Thank you for the opportunity to comment on the Gerard Preliminary Plat, #LP-08-00012. I recommend that this plat utilize a Group B water system to serve the 8 lots. A well site inspection must be performed to approve the site where the well is. The group B workbook and all associated paperwork must be turned in and the system design approved prior to final plat approval.

Holly Myers
Environmental Health Director
Kittitas County Public Health
(509)962-7584

GERARD PLAT
 PART OF SECTION 14, T. 18 N., R. 18 E., W.M.
 KITITAS COUNTY, WASHINGTON
 -- PRELIMINARY PLAT --

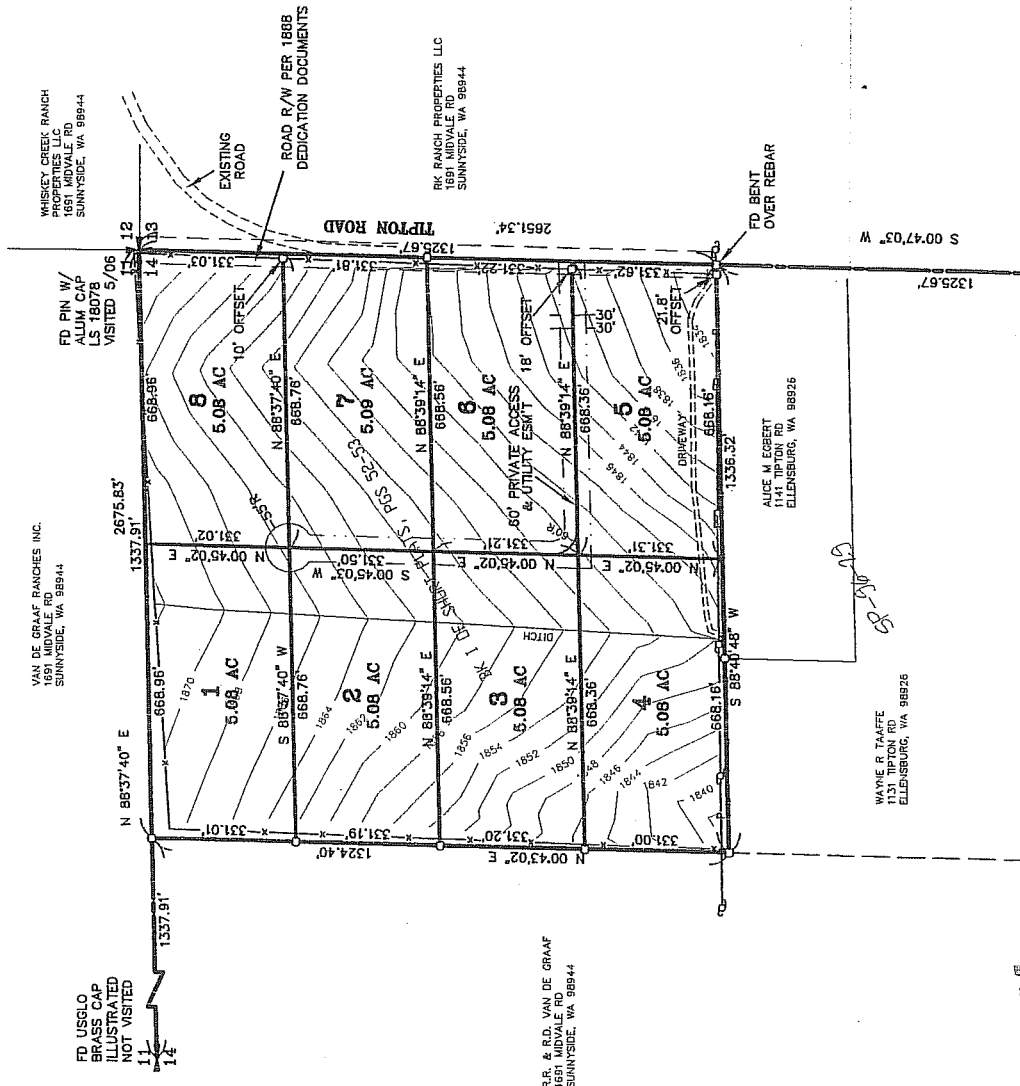
Soil logs are required for each lot where installation of a septic system is intended.
